CITY OF ALBUQUERQUE

Re: Apartments at 633 Adams Street NE, Traffic Circulation Layout
Architect's Stamp dated 11-14-09 (J17-D032)

**Re: 633 Adams St NE, New Building Grading and Drainage Plan
Engineer's Stamp dated 3-3-10 (J17/D032)**

**Re: Apartments at 633 Adams Street NE, Traffic Circulation Layout
Architect's Stamp dated 10-26-09 (J17-D032)**

TRAFFIC CONTROL PLAN

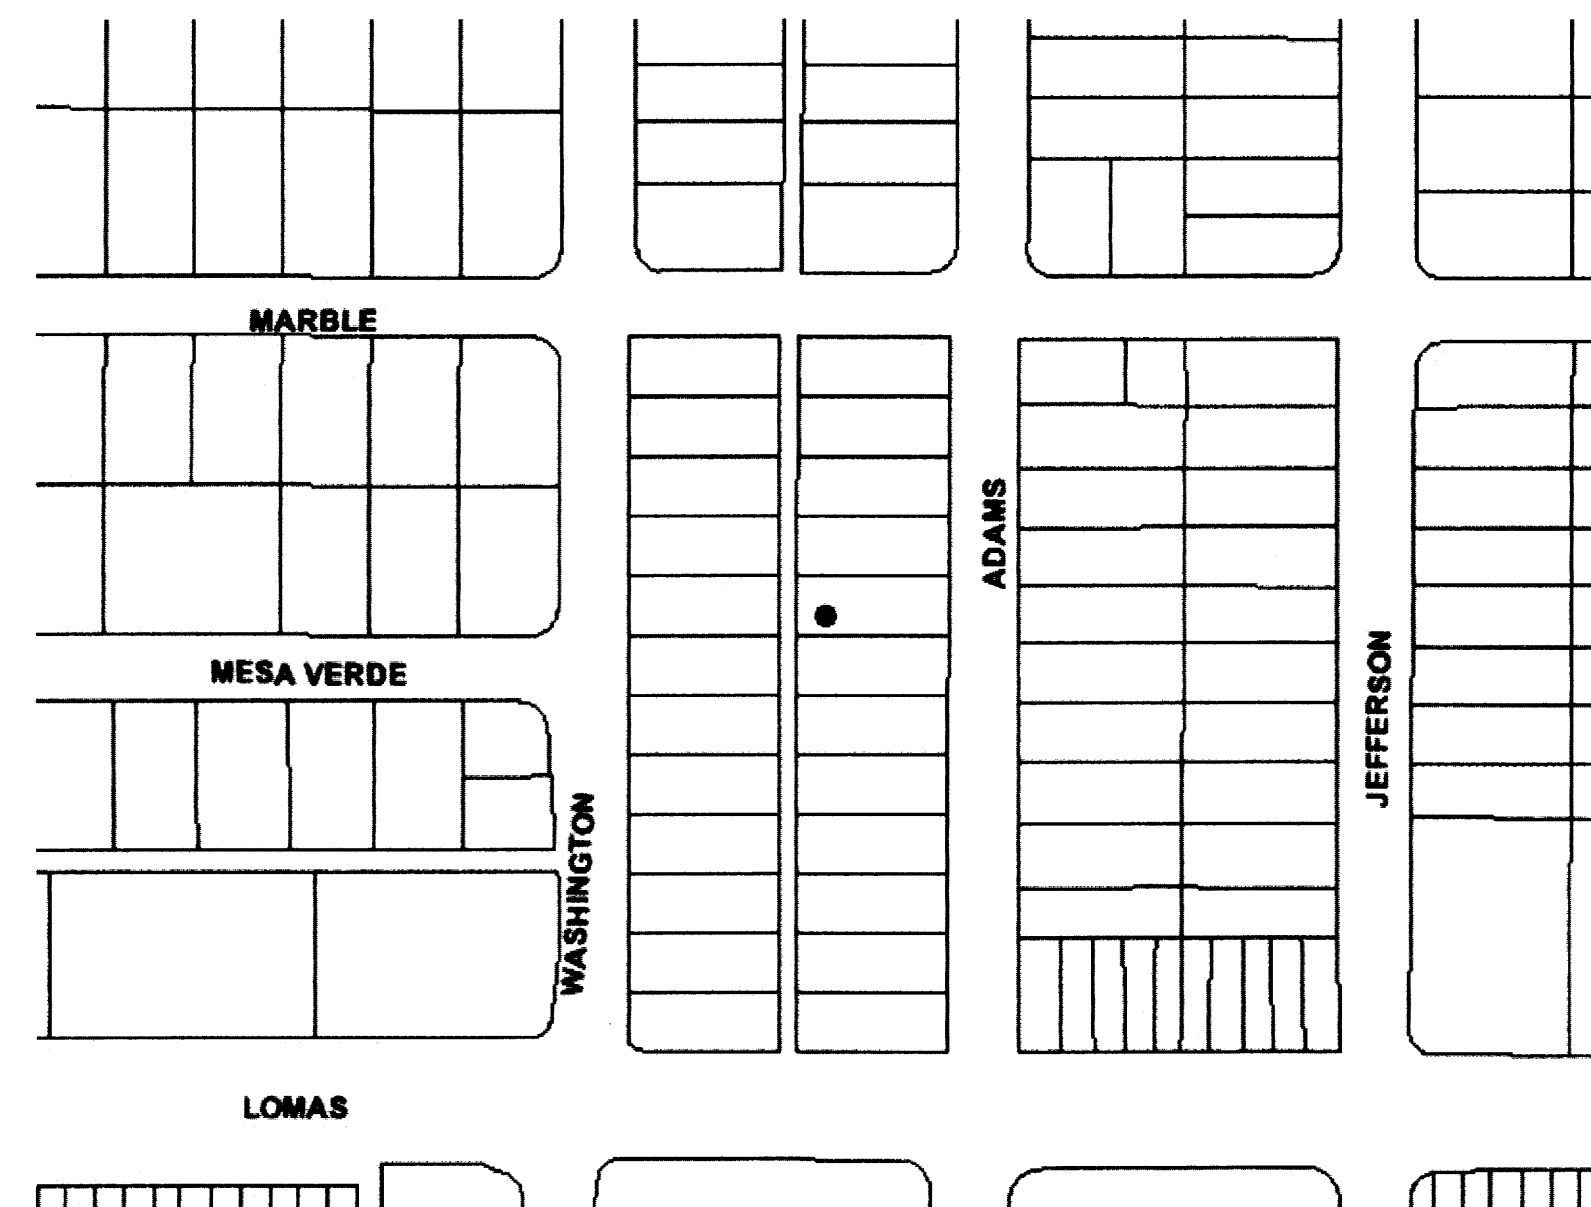
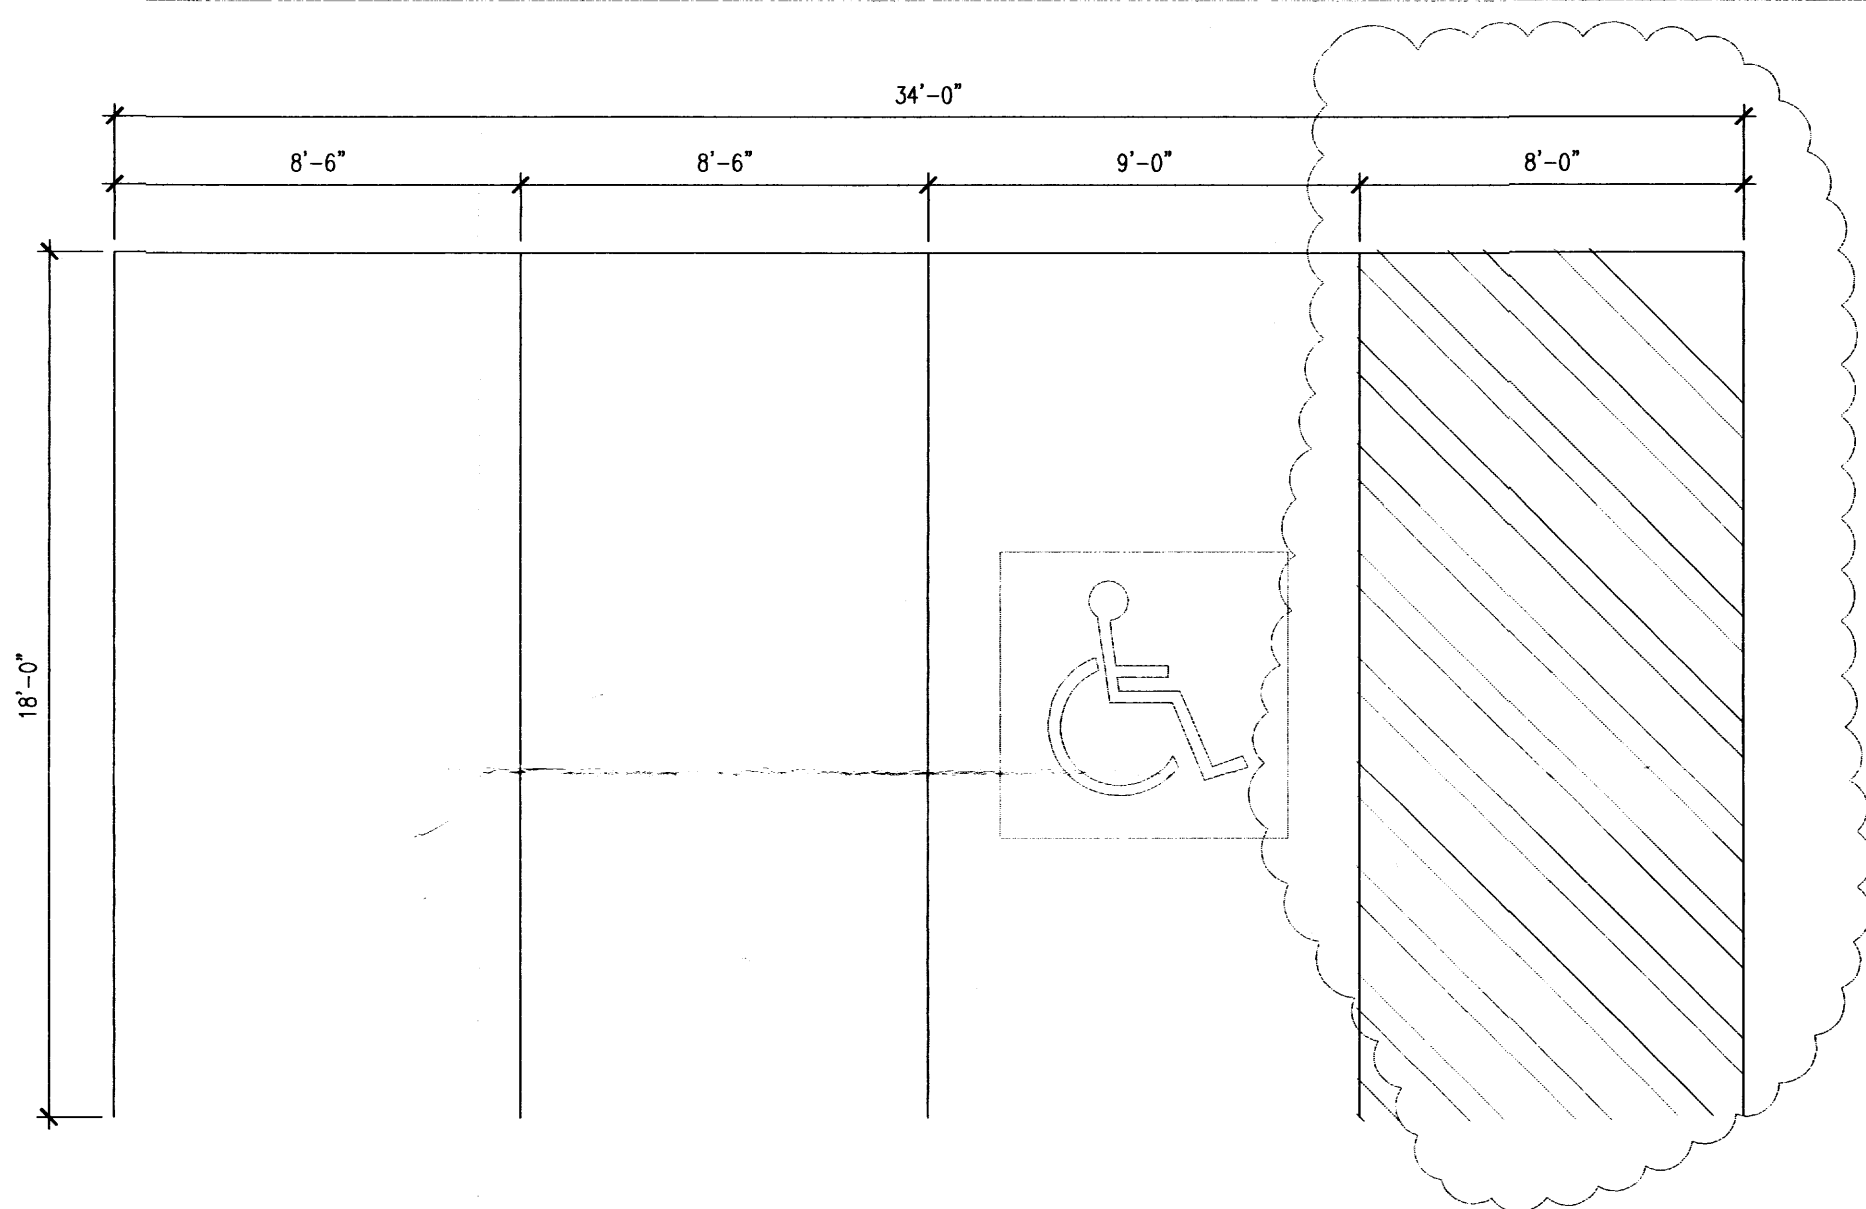
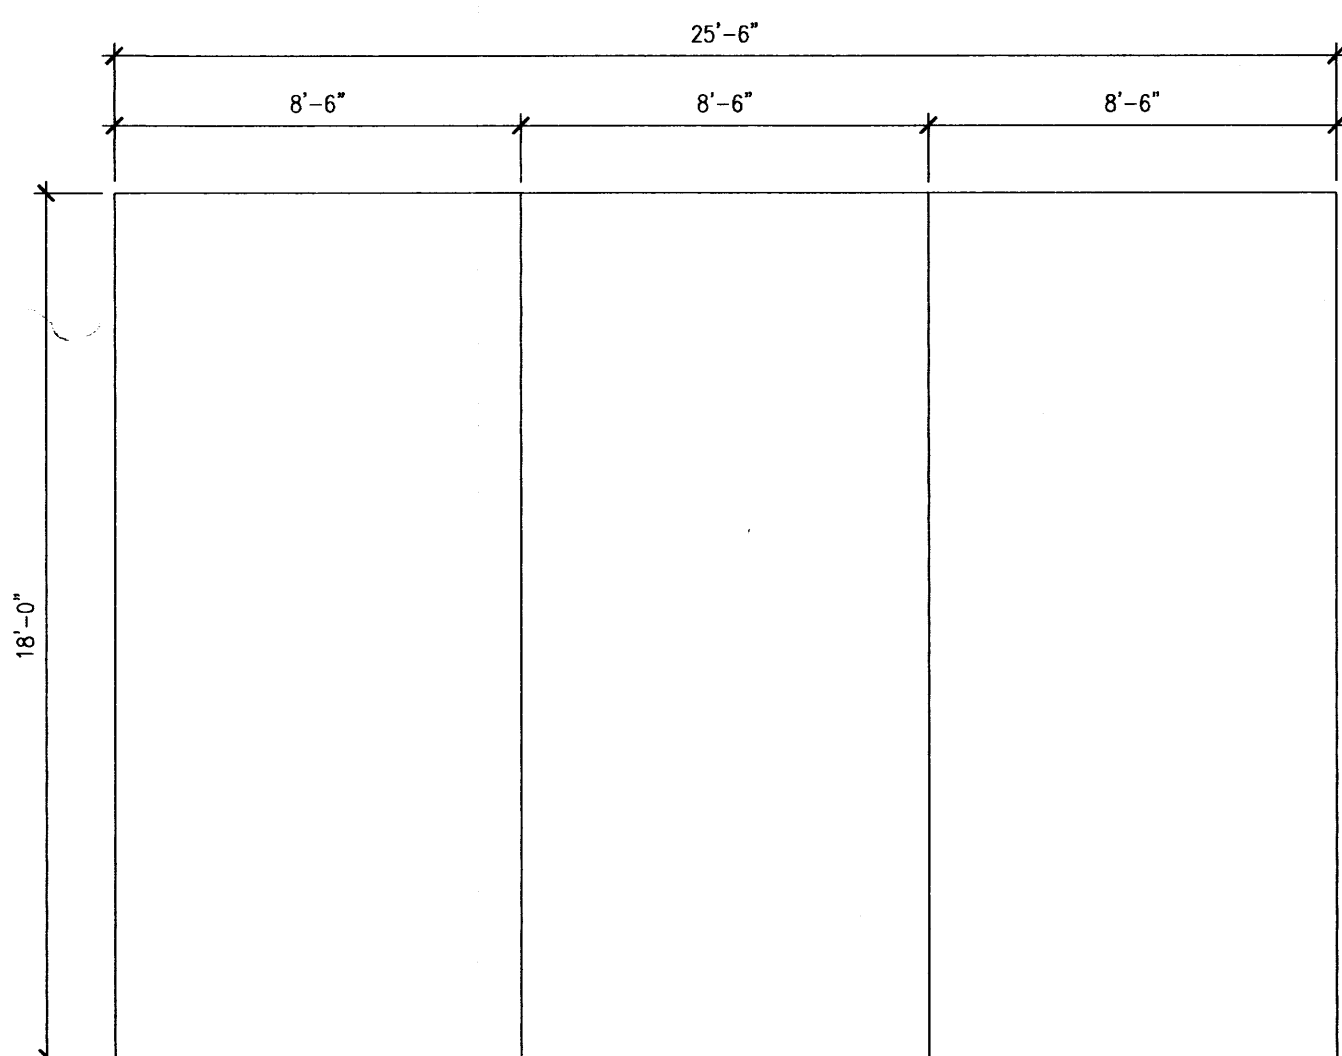
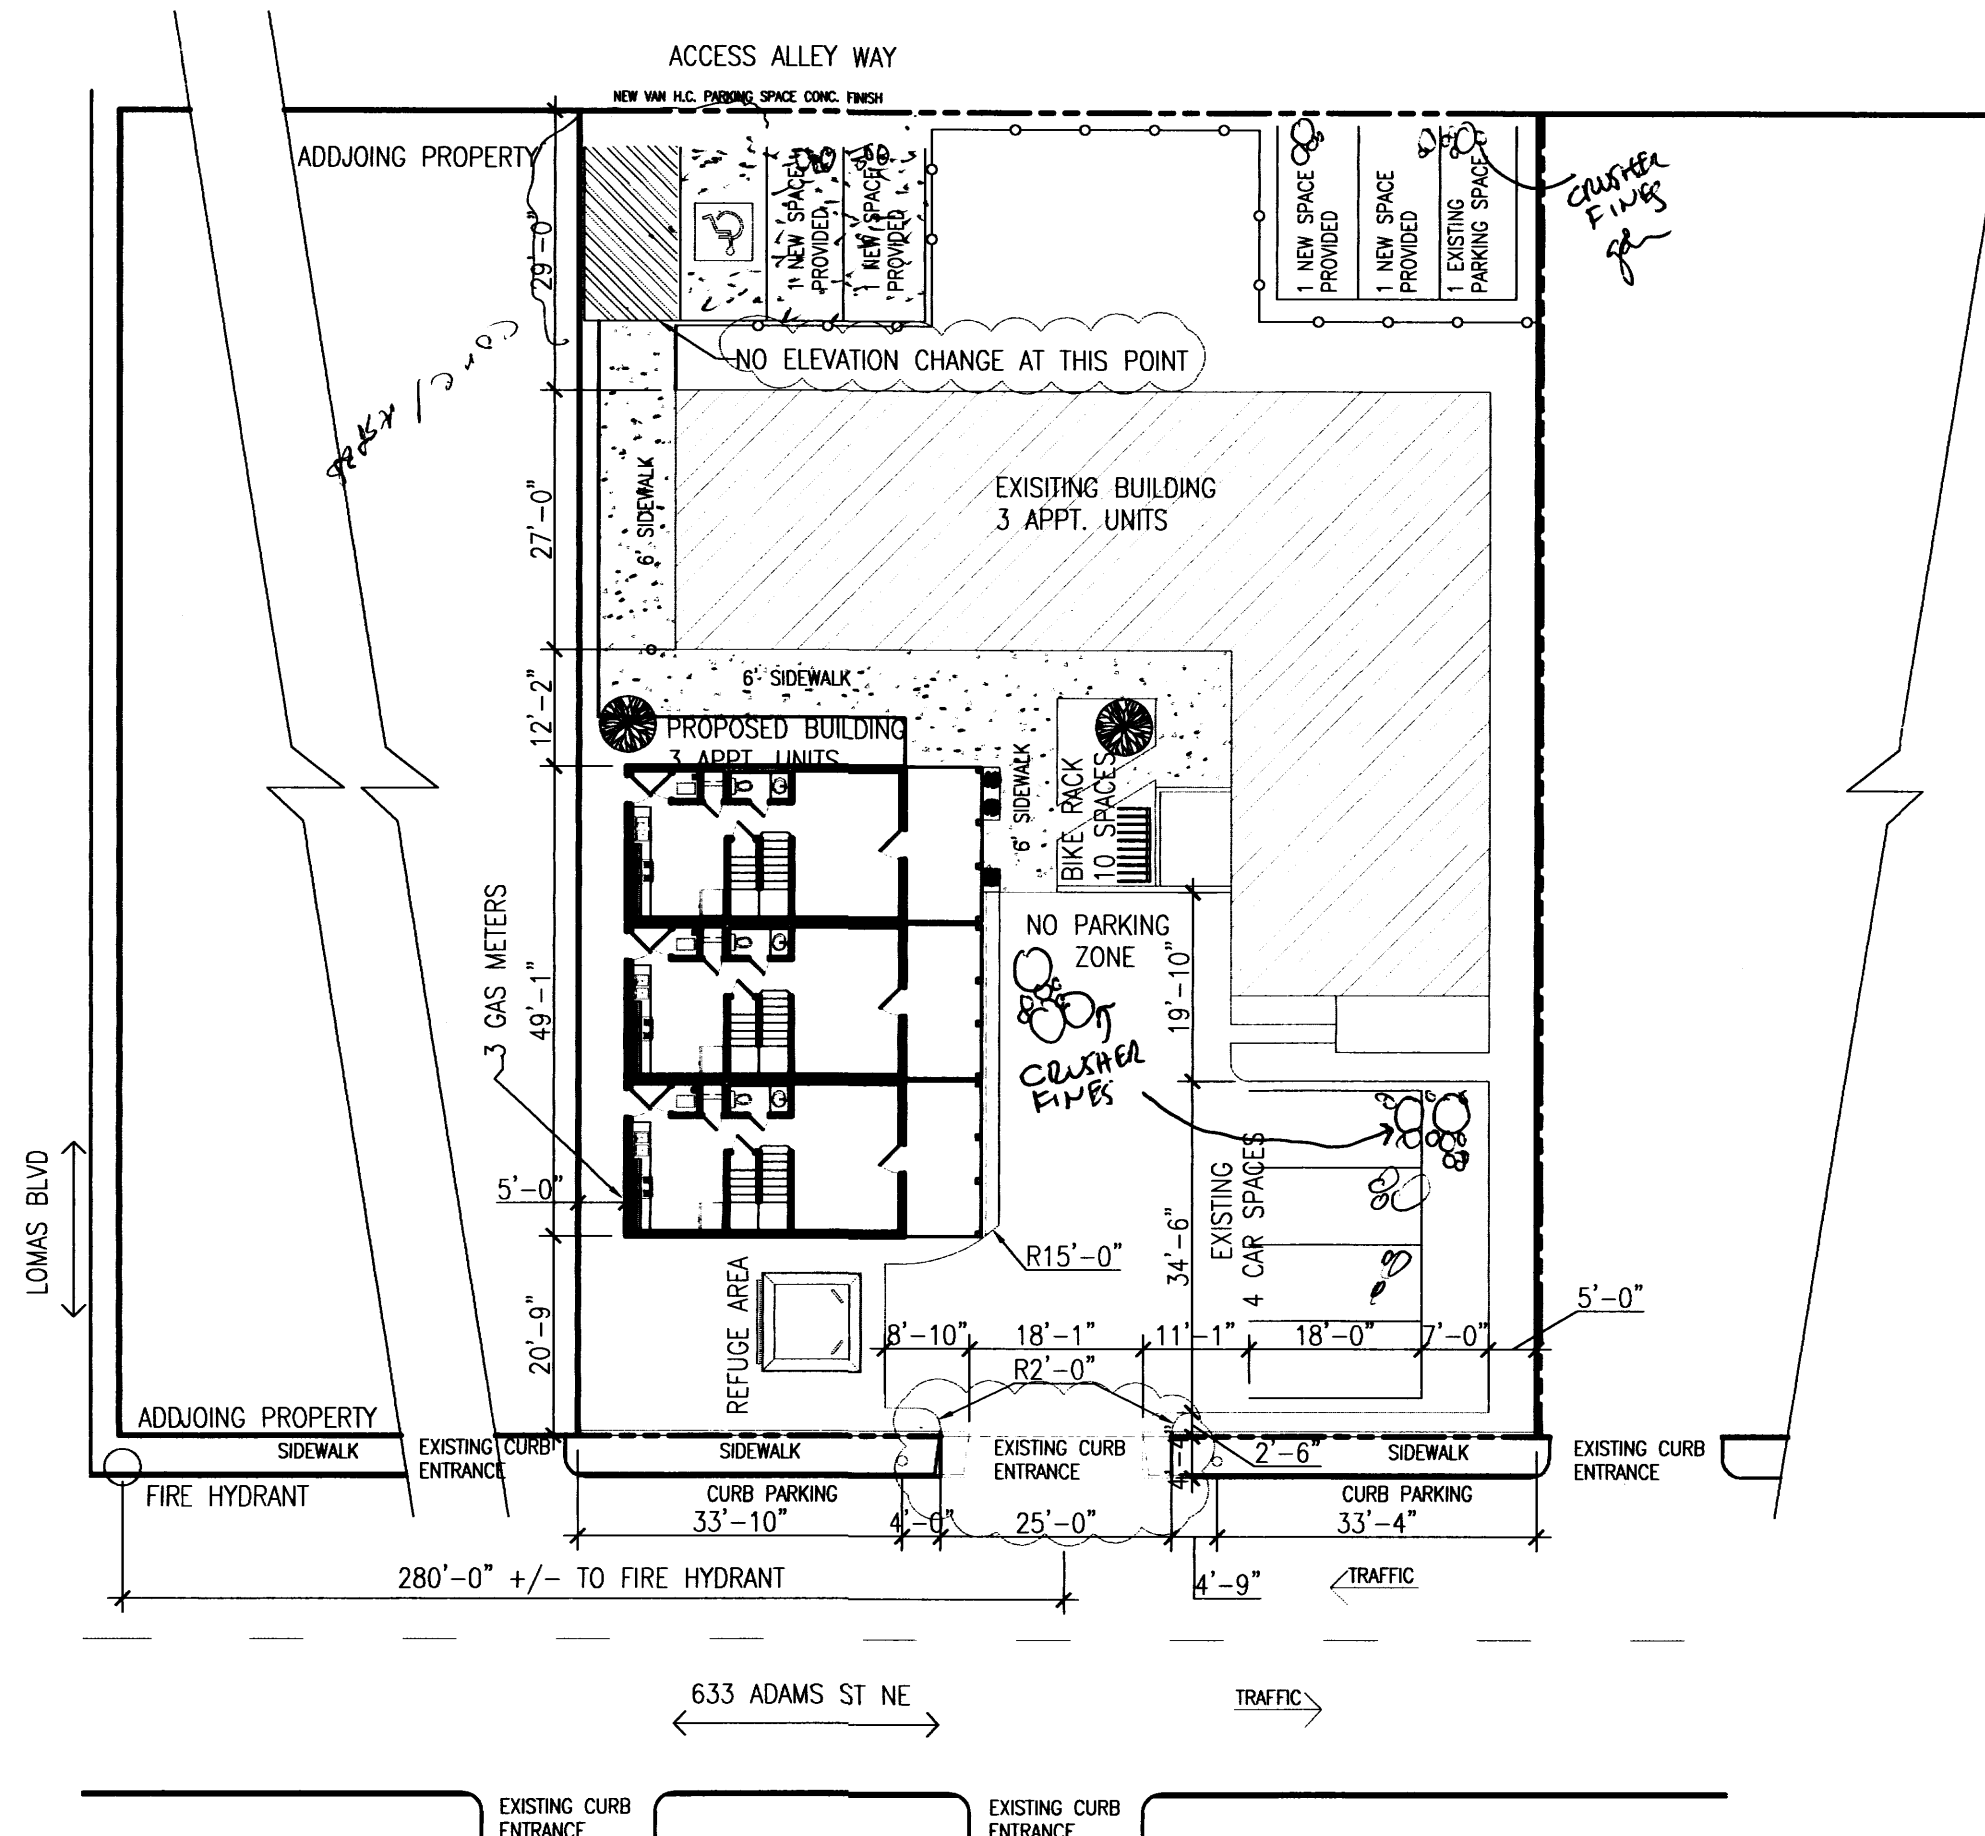
1. Build notes, referring to specific City of Albuquerque standards, must be provided for all items proposed within the right of way.
2. The handicapped space must include an 8-foot wide van access aisle.
3. Provide a legend defining all linetypes.
4. Clarify what portion of the parking areas are unpaved, and which are paved.
5. An ADA accessible pathway must be maintained from the handicapped parking stall(s) to the building. The ADA accessible pedestrian pathway must be a minimum of 6 feet wide. Please clearly detail this area; is the proposed sidewalk flush with the pavement? If not, a wheelchair ramp will be required.
6. Provide details for all wheelchair ramps; define the maximum slope.

1. Geometric information, such as aisle widths, parking stall dimensions, widths of all entrances, and the width of the existing sidewalk, must be provided. A full review cannot be completed without this information.

2. Please show the location of the nearest driveways on each adjacent lot. Proposed curb cuts must be located at least 22 feet from these existing curb cuts.

3. Clarify the proposed modifications to the existing curb cut. Define the existing and proposed width.
4. List radii for all curves shown; for passenger vehicles, the minimum end island radius is 15 feet.

5. Build notes, referring to specific City of Albuquerque standards, must be provided for all items proposed within the right of way.
6. The proposed parking spaces as shown along Adams Street are unacceptable. Please see the *Development Process Manual*, Chapter 23, Section 6, Part B.8.b.2, which states, "No backing from designated parking stalls into the streets is permitted." This parking stall layout is acceptable along the alleyway, due to the low traffic volume.

7. Please show a vicinity map.
8. Clearly demonstrate the 6-foot wide, ADA accessible, pedestrian pathway from the roadway to the building.
9. List the number of parking spaces required by the zoning code as well as the proposed number of parking spaces.

10. Two different scales are shown on the plan, $\frac{1}{4}''=1'$, and $1''=20'$. Neither of these scales is accurate. Please revise the drawing to be shown at a scale of 1 inch equals 20 feet.

11. Provide details for all wheelchair ramps; define the maximum slope.
12. An ADA accessible pathway must be maintained from the handicapped parking stall(s) to the building. The ADA accessible pedestrian pathway must be a minimum of 6 feet wide.
